# Comer Group Pre Planning Meeting – Centre Park Road, Marina

# Tiznow Ltd - Section 247 Meeting - Centre Park Road

Date:	22/07/2021	Time: 11.00am	Venue: MS Teams
List of Attendees: Lucy Teehan		Organisation/Department CCC Planning Department	Abbreviation LT
Fiona Redmond		CCC Planning Department	FR
Jeremy Ward		CCC Planning Department	JW
Tony Duggan		City Architect	TD
Liam Casey		CCC Parks	LC
John Stapleton		CCC Infrastructure	JS
Cathy Beecher		CCC Traffic & Transportation	СВ
Alison O'Rourke		CC Housing Department	AOR
Barry Comer		Applicant	BC
Ronan Woods		Applicant	RW
William Power		CW O'Brien	WP
Ellen Ballard		CW O'Brien	EB
Andrew Bunbury		Parkhood	AB
John Hynes		Arup	JH
James Duggan		Arup	JD
Clifford Killeen		Arup	CK
Harry Walsh		HW Planning	HW

Drawing Title:
BLOCK A-SECTION-SHEET 1 OF 3

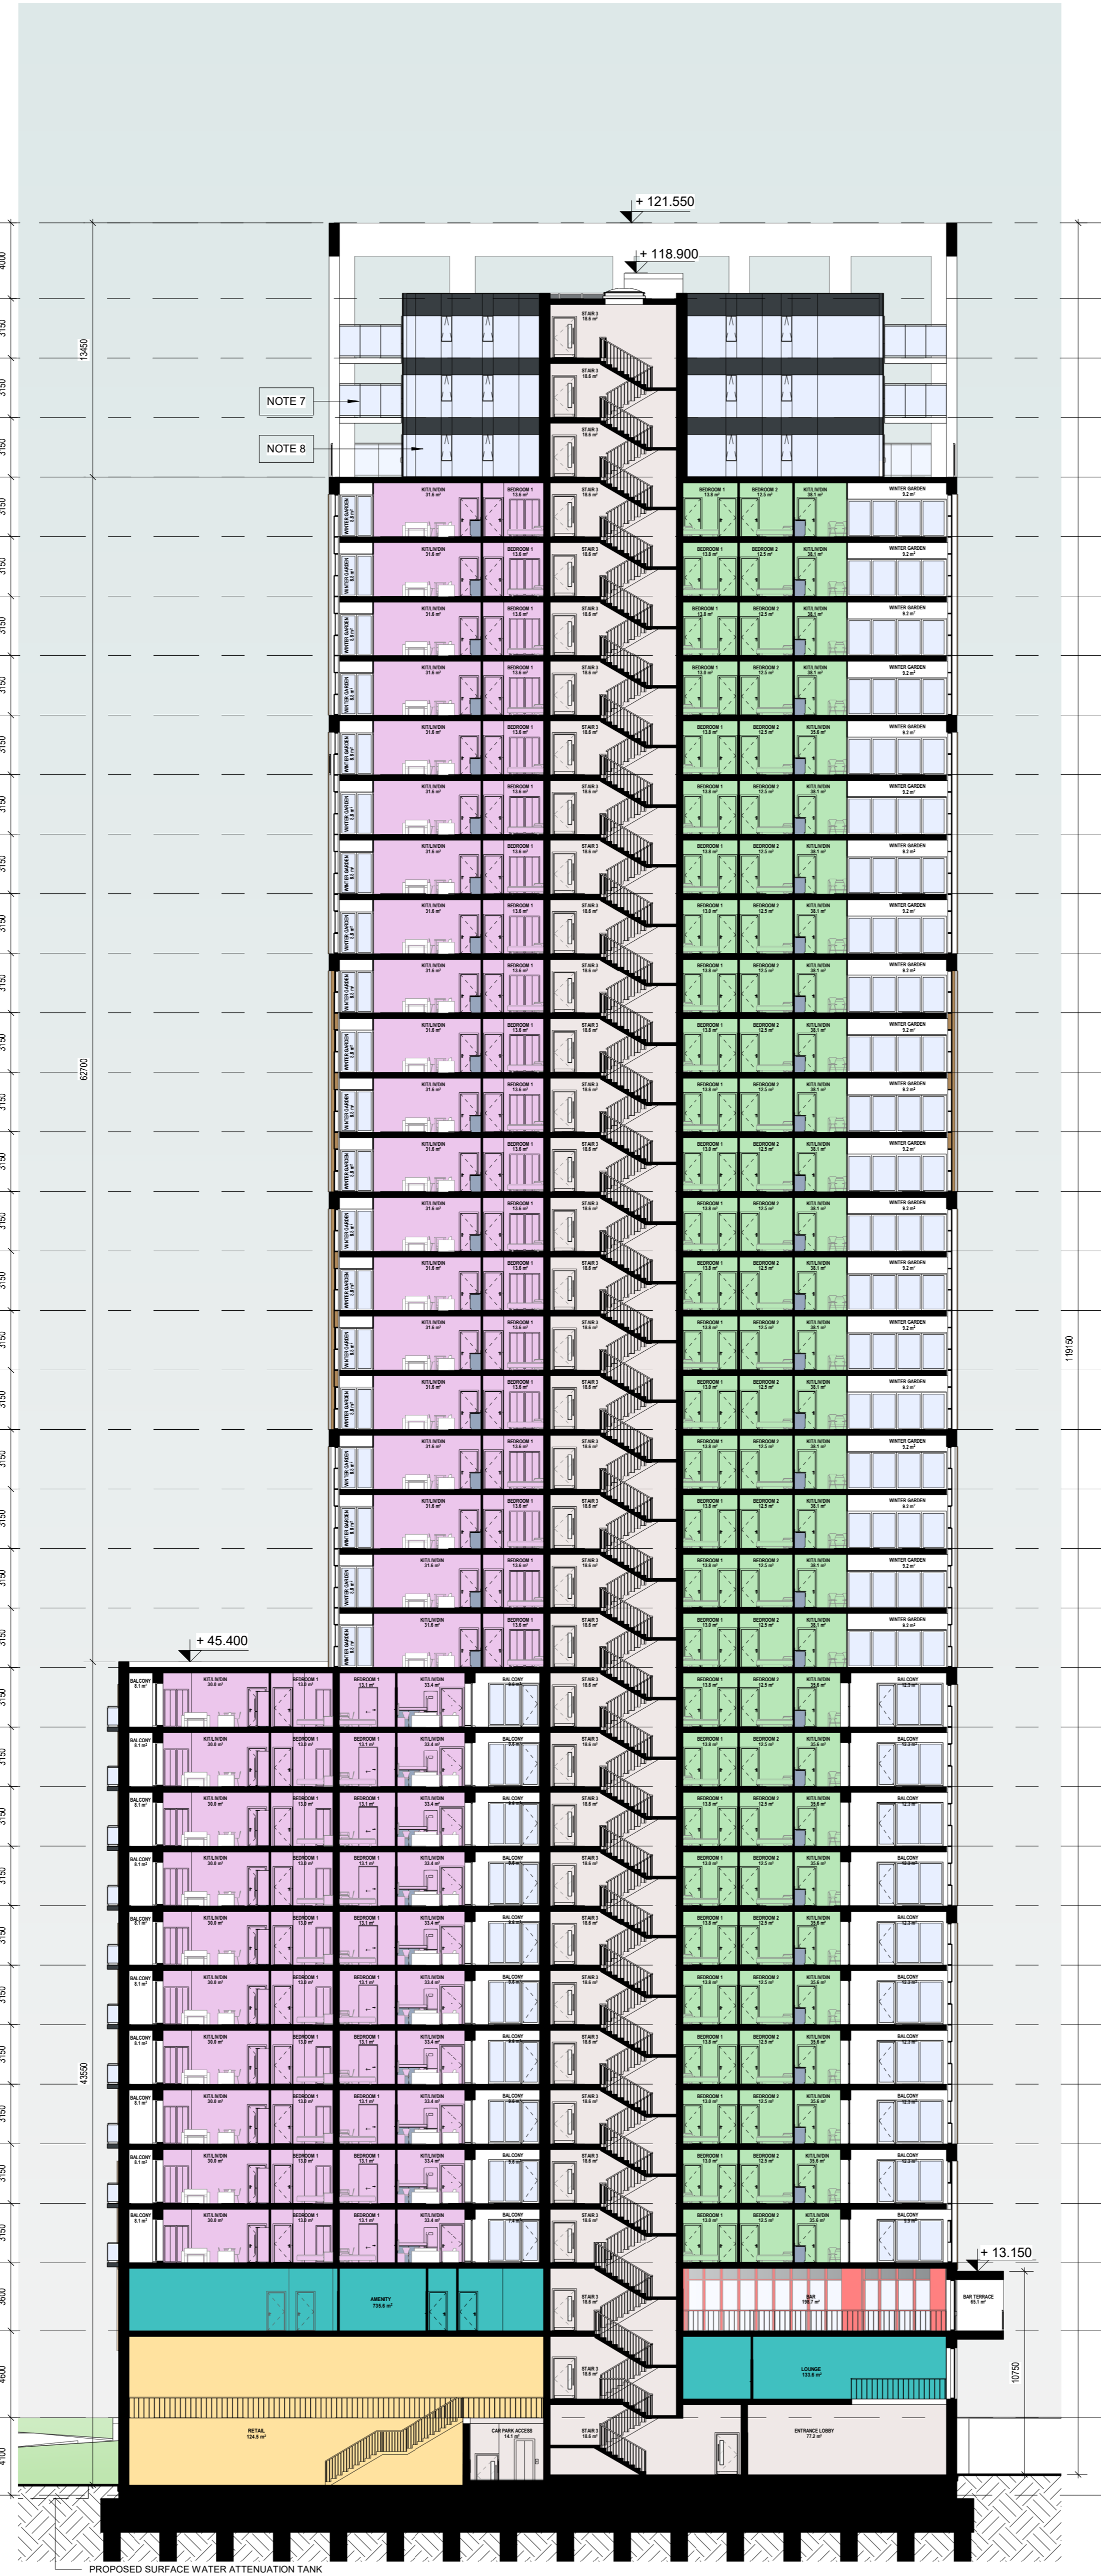
TD indicated that Centre Park Road should be treated as a street and the building heights should match those on the permitted Glenveagh scheme to the south, which were 7-9 storeys.

TD disagrees with the strategy of buildings radiating in height to the centre of the site and did not consider that the proposed heights would be acceptable to CCC or indeed ABP.

TD highlights the need for sectional detail
